From: Sarah Burrow <Sarah.Burrow@arun.gov.uk>
Sent: 14 April 2021 12:10
To: Finlay Gardner <Finlay.Gardner@arun.gov.uk>
Subject: RE: BN/8/21/HH Folly House

From: Paul Scamans <Paul.Scamans@arun.gov.uk>
Sent: 01 April 2021 10:28
To: Paul Evans <Paul.Evans@arun.gov.uk>
Cc: Finlay Gardner <Finlay.Gardner@arun.gov.uk>
Subject: FW: BN/8/21/HH Folly House

Please find attached information regarding the surface water drainage. This was investigated and determined as part of the extension works. A 9.6m³ Polystorm soakaway has been installed under the front drive to take the storm water from the carport, existing property and the new extension to the side.

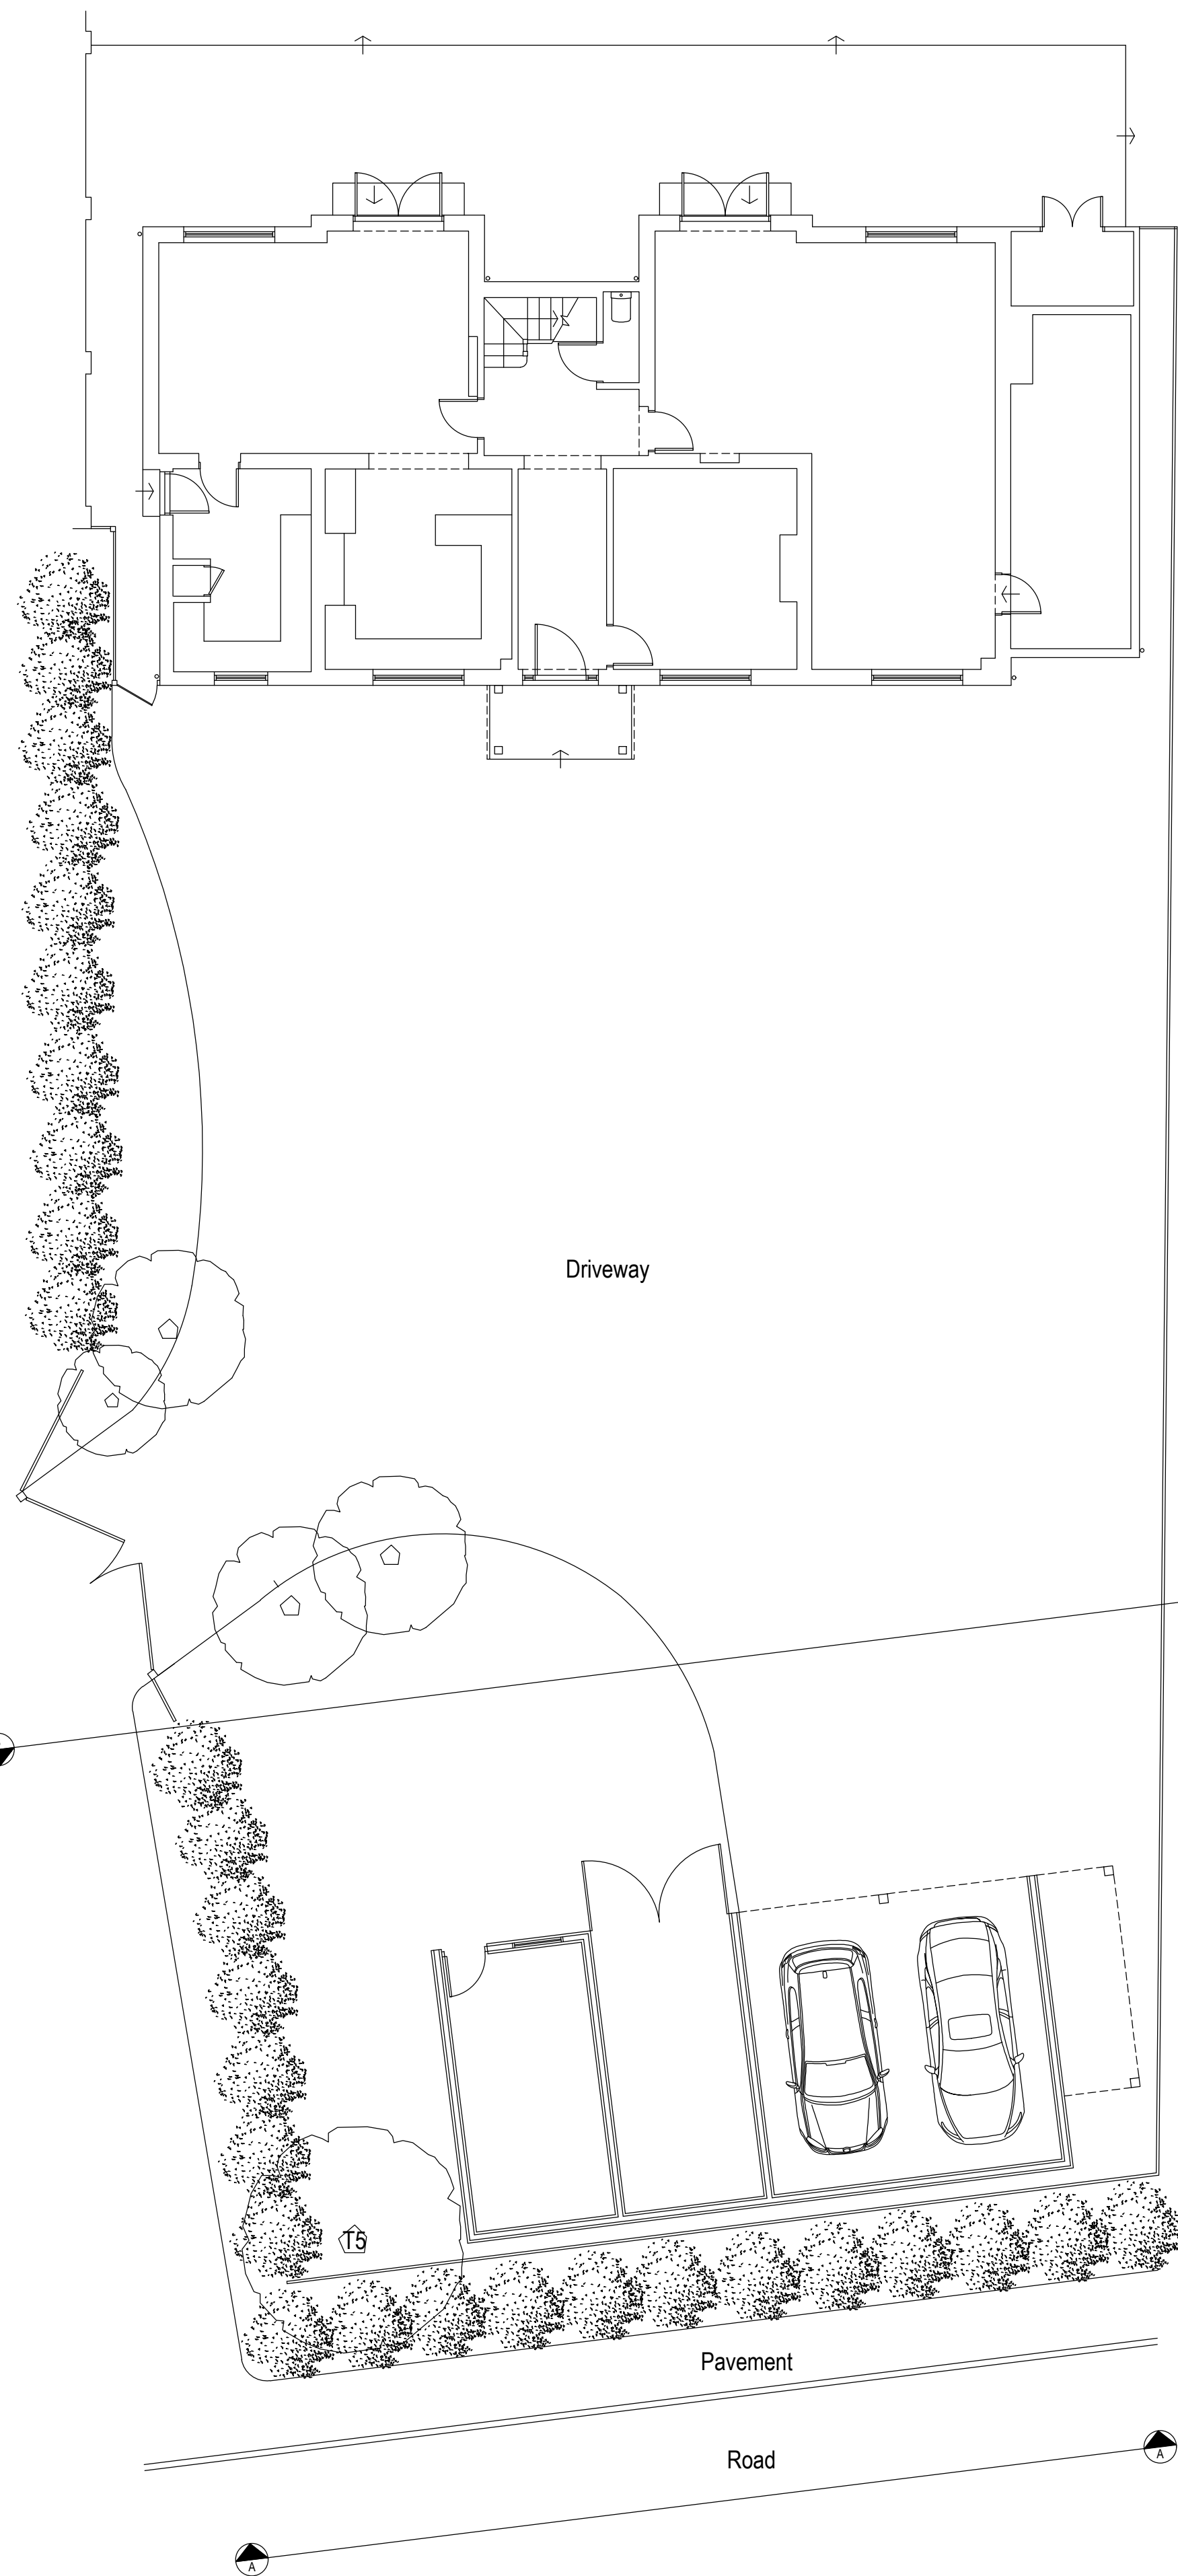
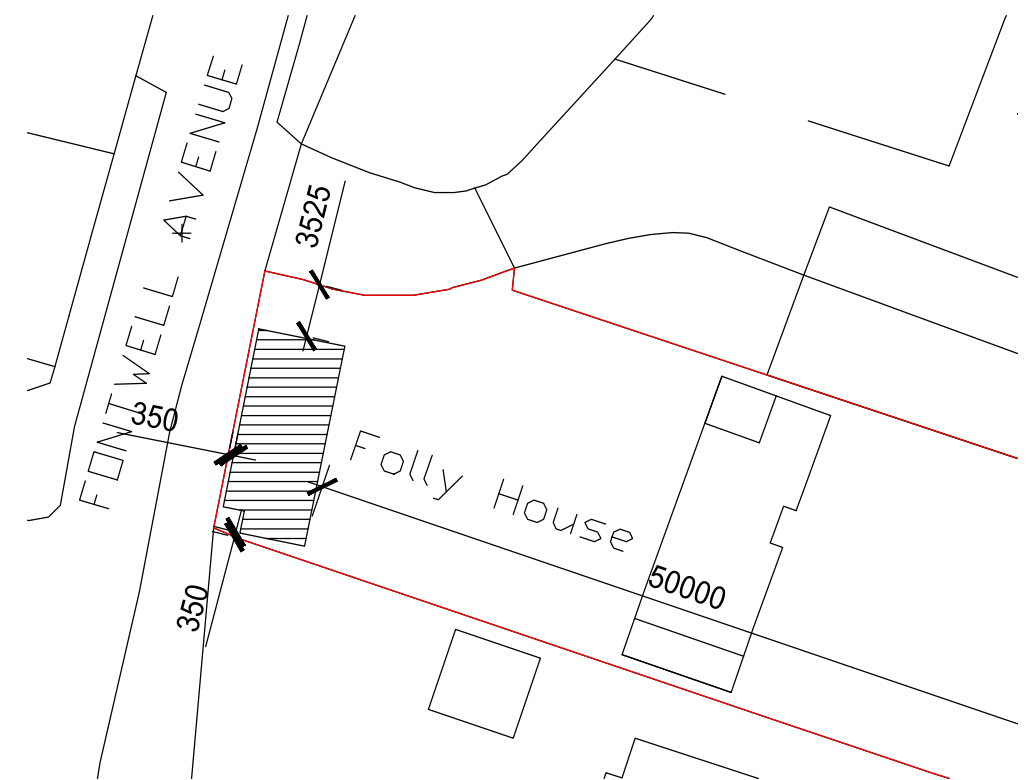
I'm afraid there is not enough information or detail in this layout for me to be able to recommend that the condition is not applied. There is no infiltration testing or groundwater monitoring supplied to inform/justify the design, no calculations and no construction details.

It is also worth noting that the site lies within the outer groundwater protection zone (Zone 2 – Subsurface activity), therefore we will need to consult the EA regarding infiltration structures, there is a chance that they will want infiltration kept to shallow depths to avoid any contamination of the groundwater in this area (or request additional filtration methods).

I have discussed this with Paul and Roger and they are agreed that seeing as Building Control have already been involved with the extension that it will over complicate the situation for us to get involved at this stage. It is an undesirable outcome from my point of view, as if we had known that the car port was to be included with the extension application we would have requested PCENG2 at the time and there would have been more oversight in a delicate area from a drainage point of view (due to the groundwater protection zone). You may disregard my request for PCENG2 to be applied in this case.

Plan area – 76m²
Effective Design Area – 76m² x 1.29 (30 degree pitch) = 98.04
Design Area x Rainfall – 98.04 x 0.04 = 3.9216

4m³ soakaway required for car port which has been allowed in the proposed soakaway fitted as per attached.
